Environmental Health Division
1675 W. Garden of the Gods Road
Suite 2044
Colorado Springs, CO 80907
(719) 578-3199 *phone*
(719) 578-3188 *fax*
www.elpasocountyhealth.org

Fall Mountain Farm, PPR-22-46

Please accept the following comments from El Paso County Public Health for the request referenced above:

OWNER NAME AND ADDRESS:
 STEVE & CATHY ROSCIO
 FALL MOUNTAIN FARM COMPANY
 16300 MT. HERMAN LANE
 MONUMENT, COLORADO 80132
 PHONE: (719) 800-1244
 EMAIL: info@FallMountainFarm.com

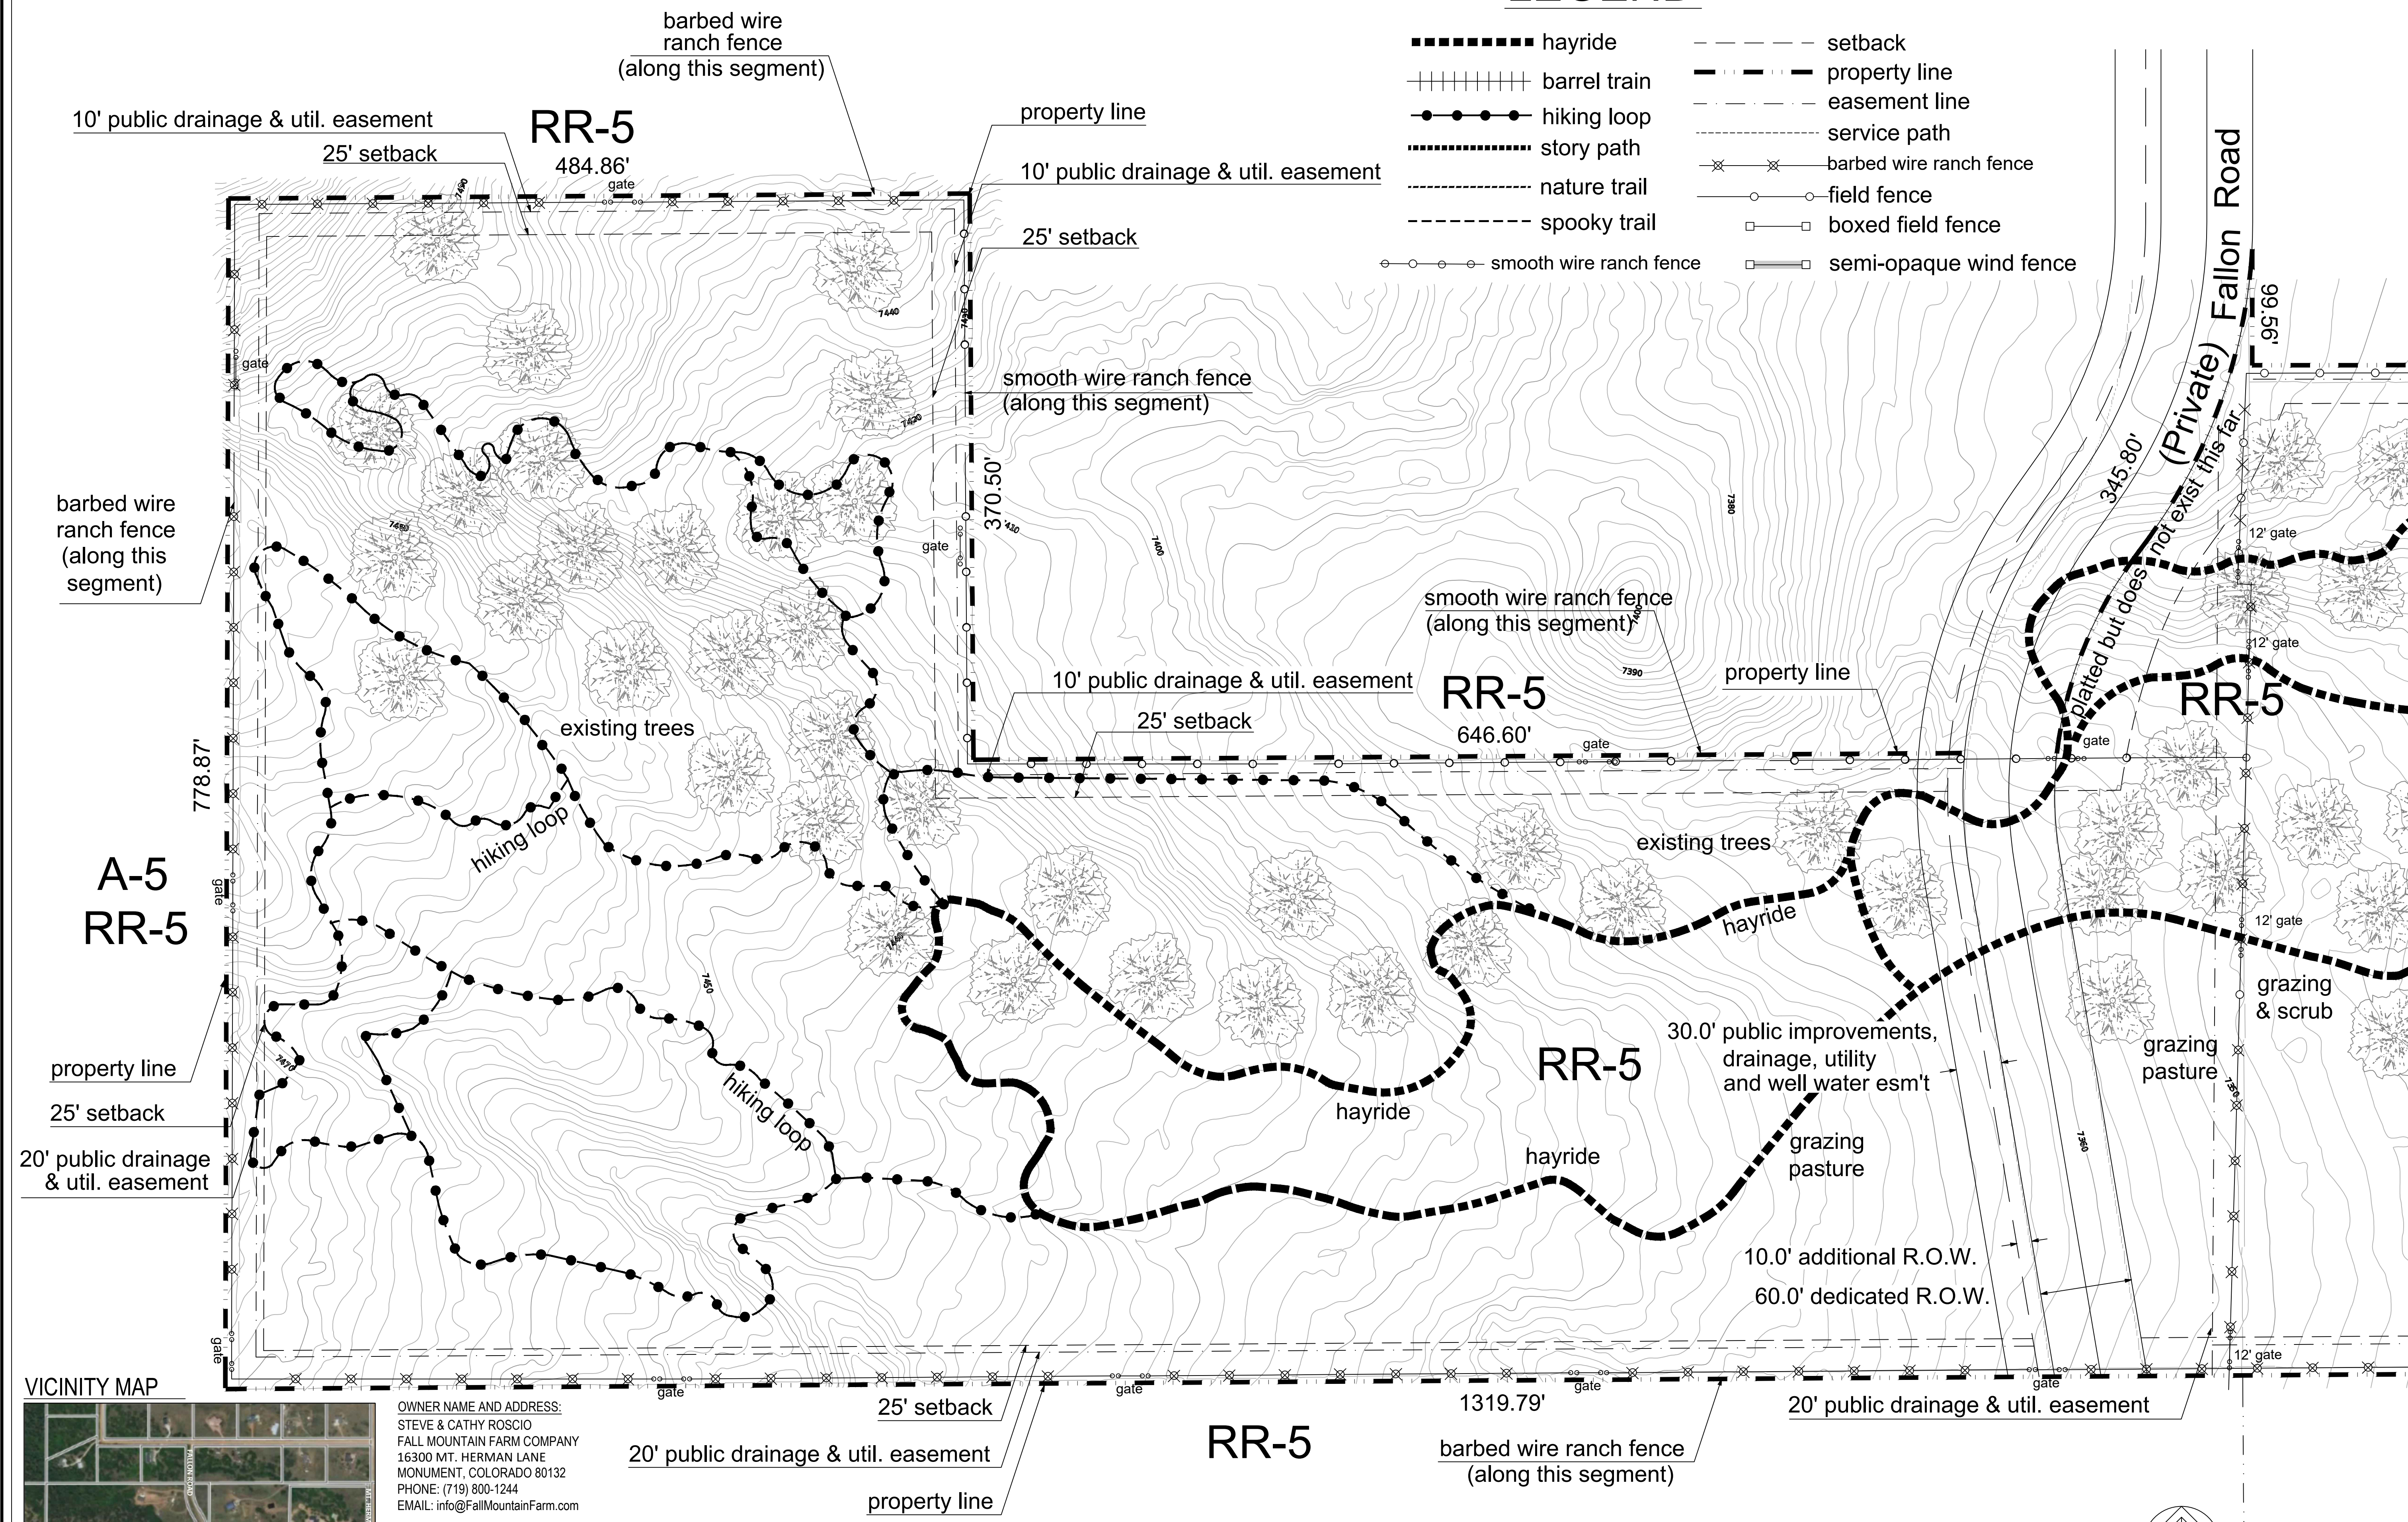
- Animal waste must be collected and removed to minimize odors, and insect/rodent attraction.
- The existing residence is connected to an onsite wastewater treatment system (OWTS) installed and approved in 1987 for a 4-bedroom house. Please locate the OWTS soil treatment area and make sure traffic and parking will not be in proximity to the OWTS.
